A1 in Northumberland - Morpeth to Ellingham

Our ref: PL00702582  
Your ref: TR010059

**Application by Highways England for an Order Granting Development Consent for the A1 in Northumberland – Morpeth to Ellingham project**

**Historic England Respond at Deadline 2 (D2)**

## **Appendix B Working Area around West Linkhall Scheduled Monument and North Charlton Scheduled Monument**

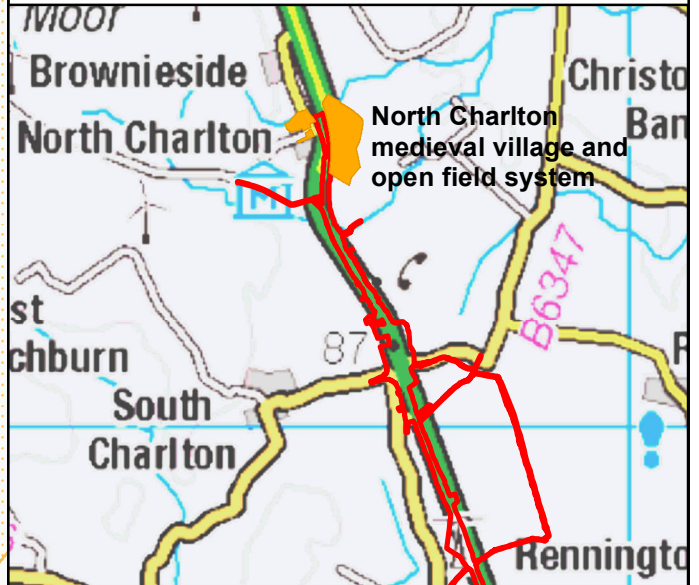
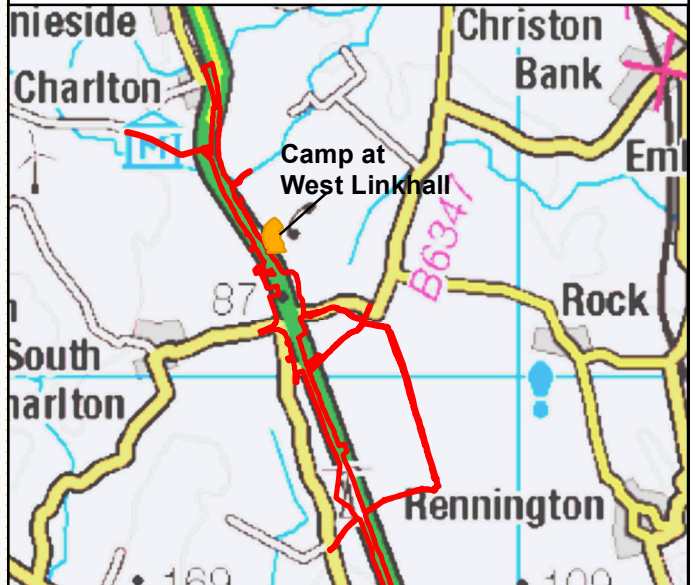
Historic England notes, and welcomes, the submission of document 'Appendix B Working Area around West Linkhall Scheduled Monument and North Charlton Scheduled Monument'.

The stated intention of Highways England was to avoid any direct impacts on these scheduled monuments, which we welcomed. However, the concern was that the plans previously provided did not show the DCO boundary and boundary of the scheduled monuments at a scale which allowed this to be confirmed.

The submitted document referred to above allows confirmation on this issue - the boundary of the DCO does not extend into the scheduled monument. This provides us with reassurance on this key issue.

The remaining issue for us, discussed above, was to ensure that the DCO boundary did not include any part of the two scheduled monuments (NHL 1018499 and NHL1018348) which lie close to or adjacent to this boundary. The further information submitted by the applicant confirms this to be the case, and that no part of the DCO area intrudes into these scheduled monuments. This is welcomed.
